City of Sydney

30 June 2011

**Re: Dr Chau Chak Wing Building, UTS Sydney – Project Application
(MP09_0153)**

TITLE
ROOF PLAN

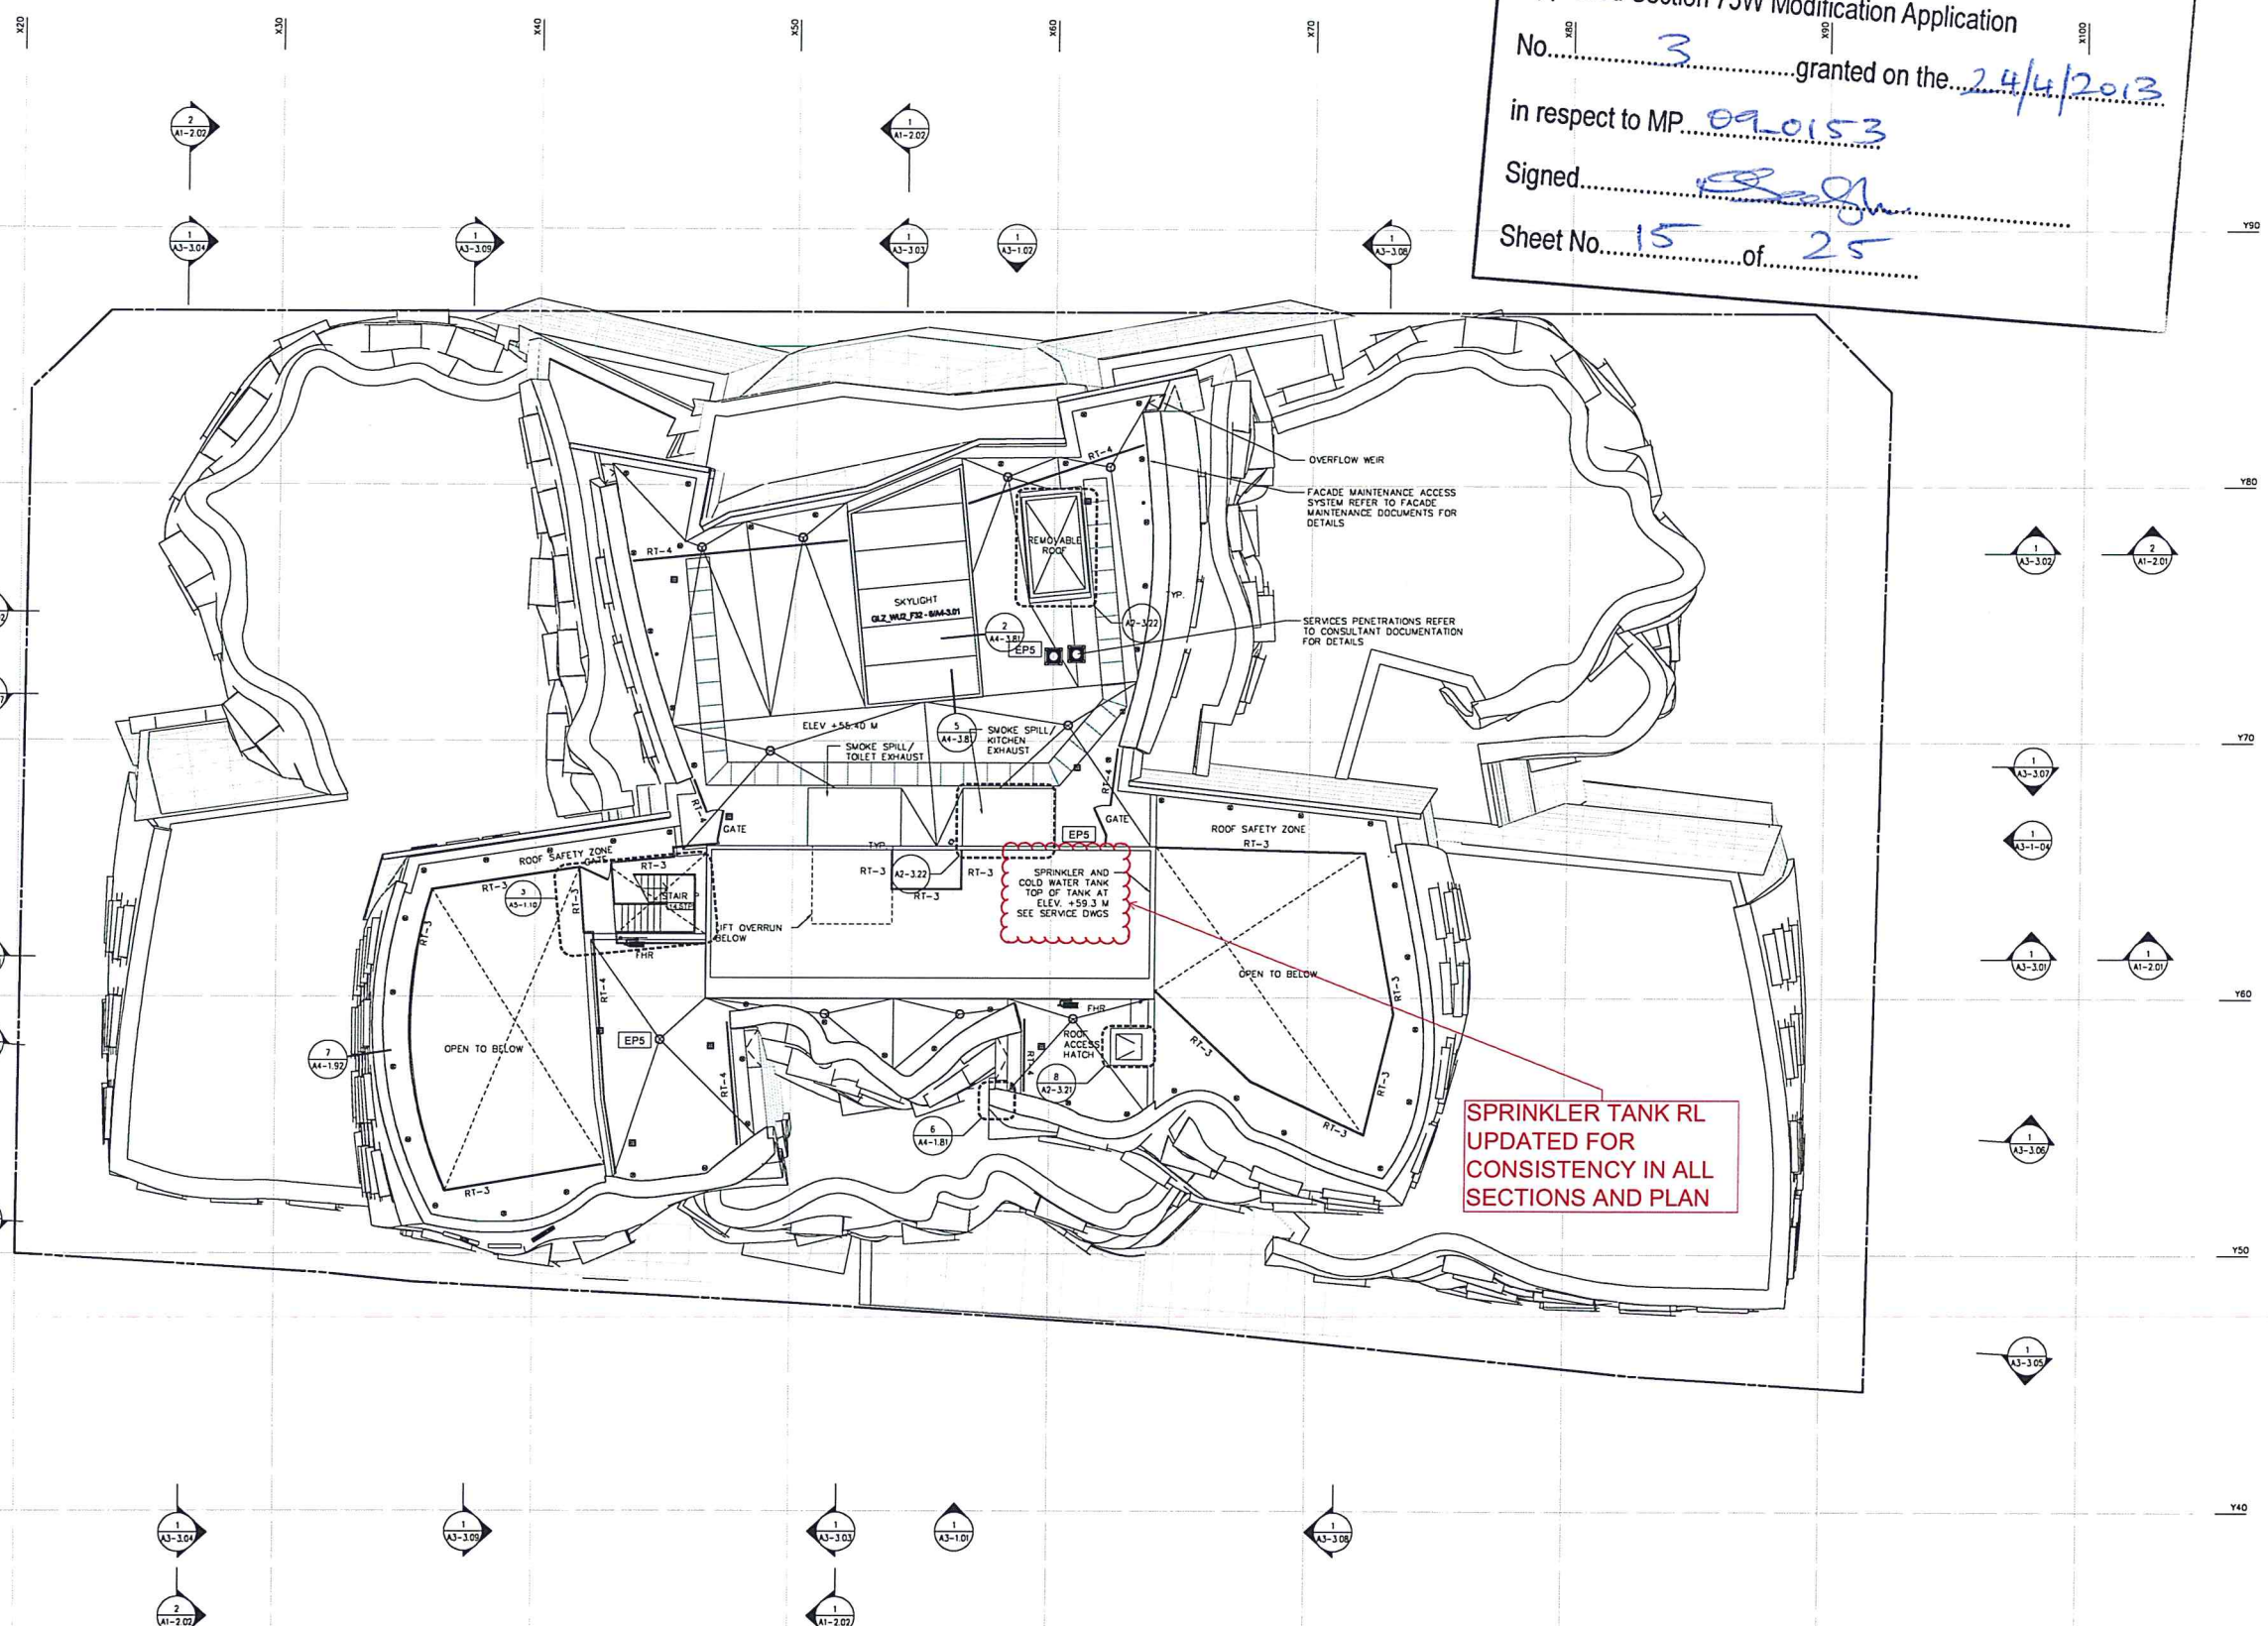
From the third floor to the roof level, the building overhangs the road reserve (footpath and carriageway) in three locations. The overhang appears to increase from floor to floor, with the elements dimensioned on the roof plan as extending beyond the site boundary 1002mm, 1406mm and 1500mm.

The City's controls allow minor projections beyond the site boundary in the order of 450mm, for articulation elements such as awnings, balconies and roof forms. The proposed building projections exceed this figure but are considered acceptable in this instance as the projections are a key feature of the building's unique design. The City does not object to the projections from an urban design perspective.
